From: Michael Eastham <Michael.Eastham@arun.gov.uk>
Sent: 27 October 2021 10:41
To: Planning.Responses <Planning.Responses@arun.gov.uk>
Cc: Claire Potts <Claire.Potts@arun.gov.uk>
Subject: FW: Chandlers BMW-MINI Worthing - A/157/21/DOC

“The landscape proposals submitted under A/157/21/DOC show the bare minimum of ground cover planting with little variation in tree and shrub species. The scheme is devoid of any frontage tree planting proposals and only 6no Birch trees 8-10cm girth to the rear. The proposed landscaping scheme is contrary to Policy D DM1 of the Arun Local Plan and the Arun Design Guide as it does not demonstrate a high standard of hard and soft landscaping to reflect the local area”.

Planting Plan 1 of 2

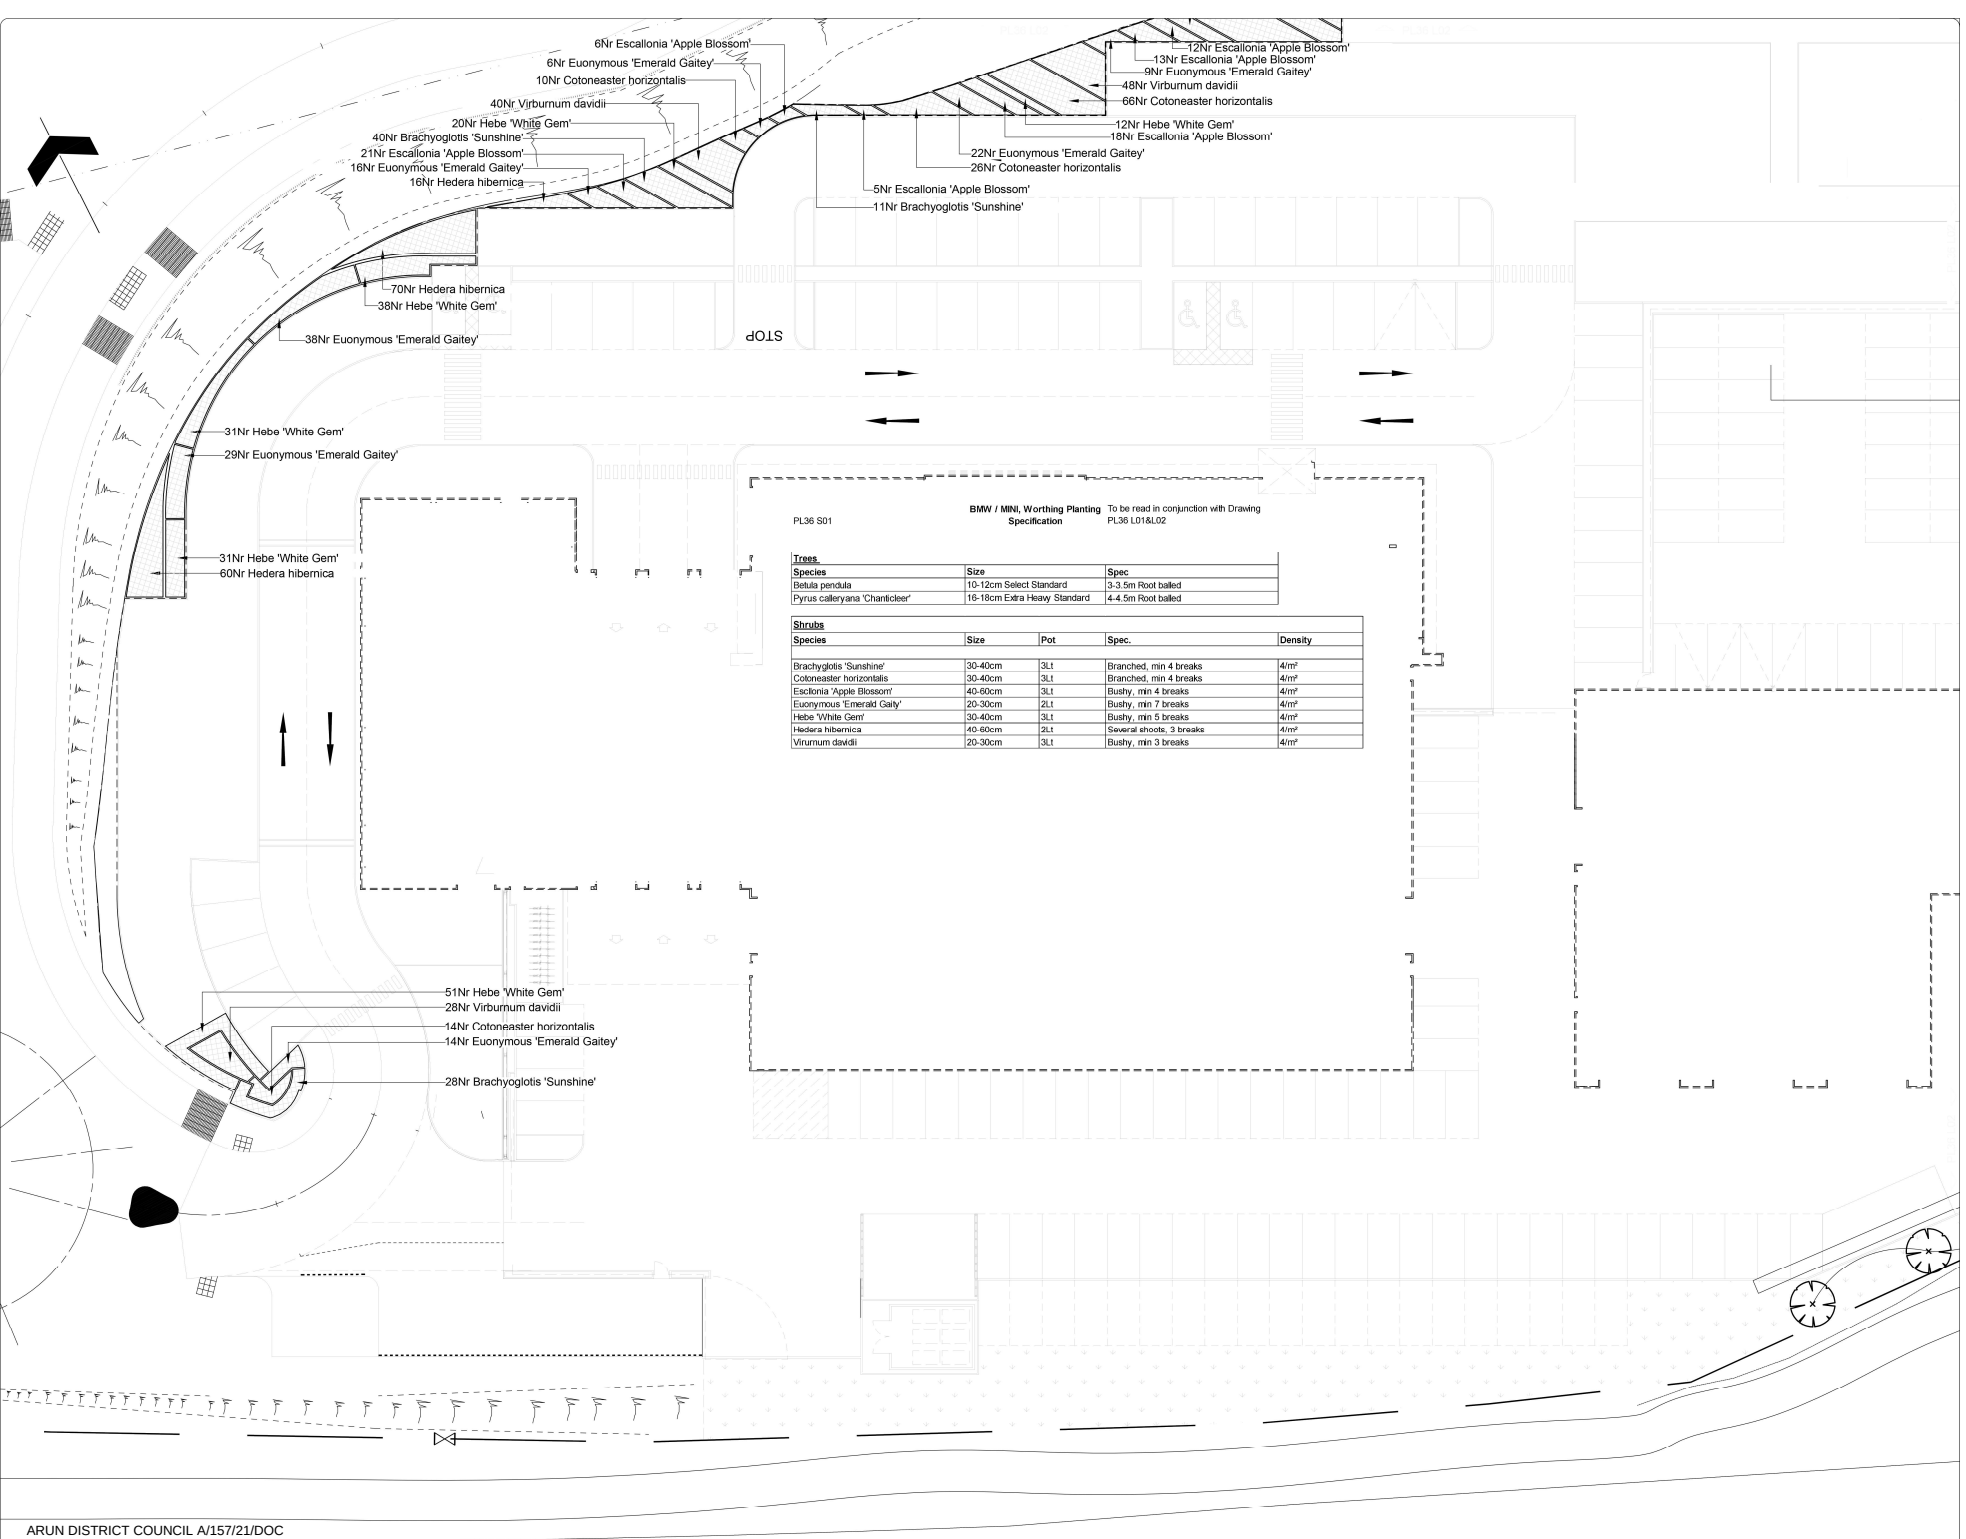
Once A/157/21/DOC has been refused the LPA expects you to submit a new discharge of condition application with a landscaping scheme based on a site based approach in which you will need to address the visuals from outline and also the site in relation to its neighbours which have the tree cover to the frontages
